WEST SUSSEX COUNTY COUNCIL CONSULTATION

| LOCATION: | Allestree Court Walton Road Bognor Regis PO21 1NN |
| SUBJECT: | BR/197/25/PD Application for prior approval under Schedule 2 Part 20 Class A for the construction of one additional storey creating 2 No. additional dwellings. |

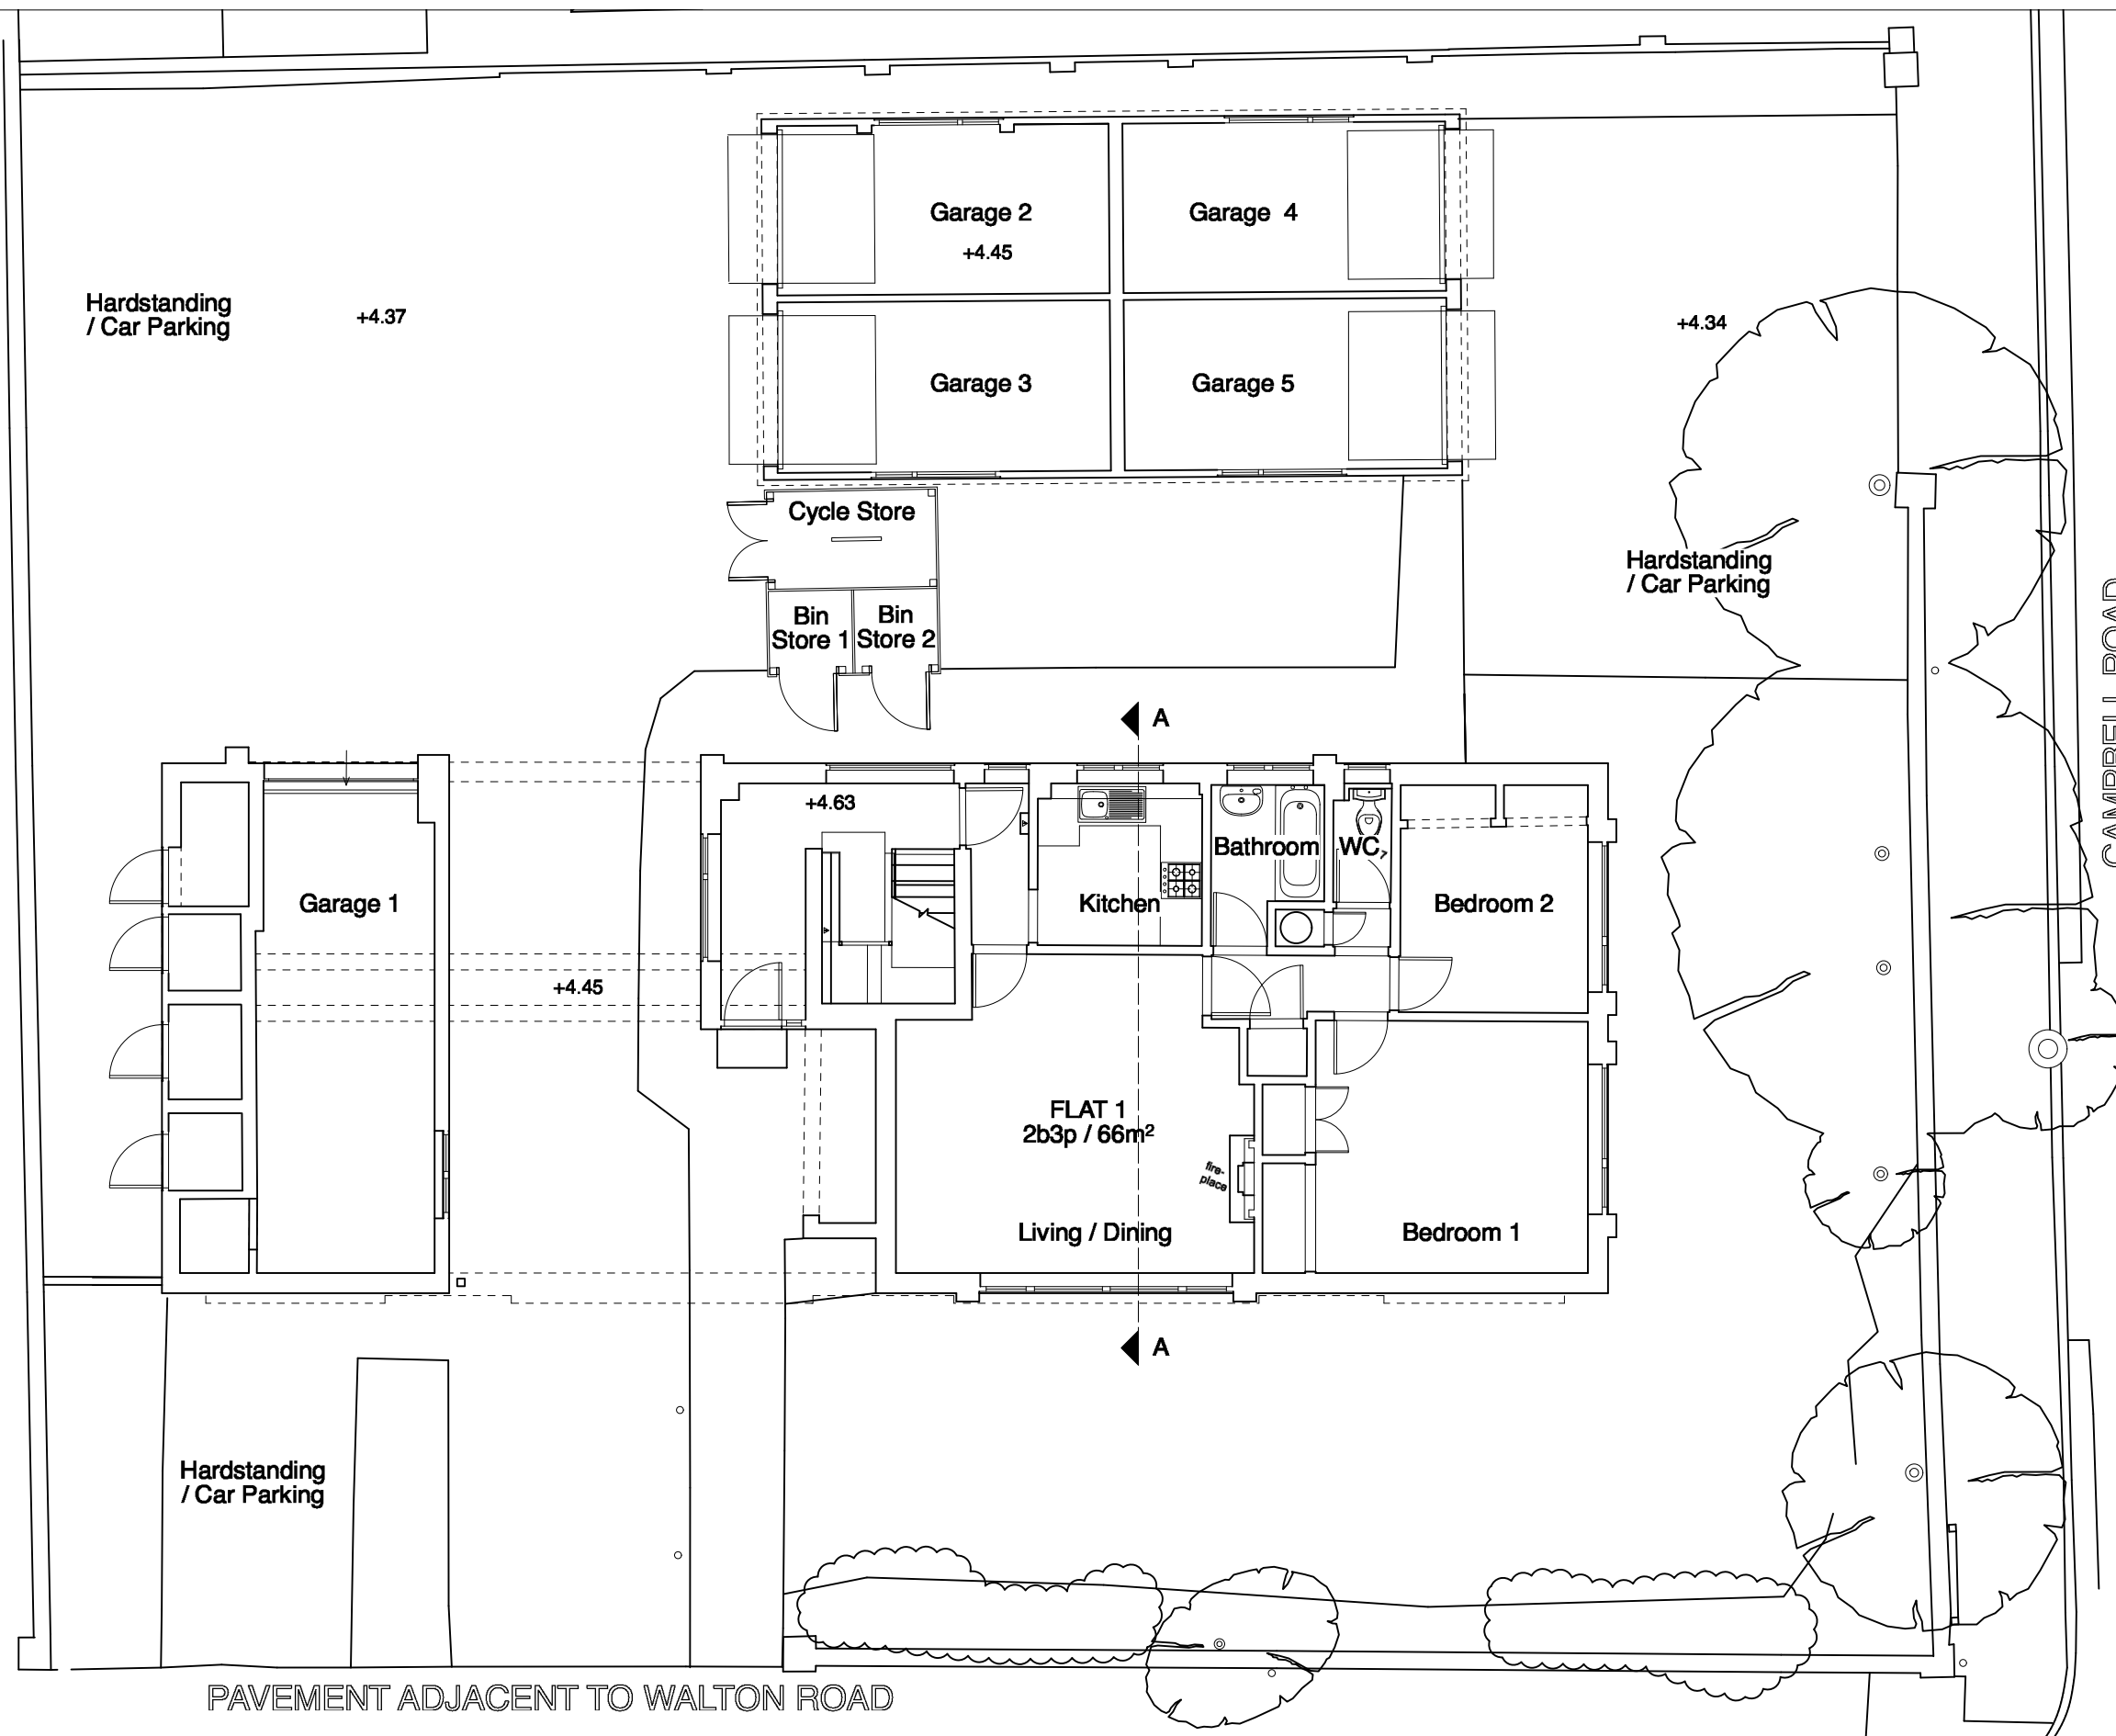
The site is accessed from both Walton Road and Campbell Road. No alterations to the existing accesses are proposed. The proposed additional storey is not anticipated to give rise to a material intensification of use of the existing junction.

The WSCC Car Parking Demand Calculator indicates that a development of this size and location would require three car parking spaces. Parking has not been demonstrated on the proposed plans, however the applicant has indicated that parking could be accommodated within the existing hardstanding areas. The LPA may wish to consider whether this would be practicable given representations from nearby residents. Parking may be required to be accommodated either on-street or within nearby paid-for provision. The LHA does not anticipate that the car parking provision would result in a highway safety concern, but the LPA may wish to consider potential amenity impacts on on-street parking.
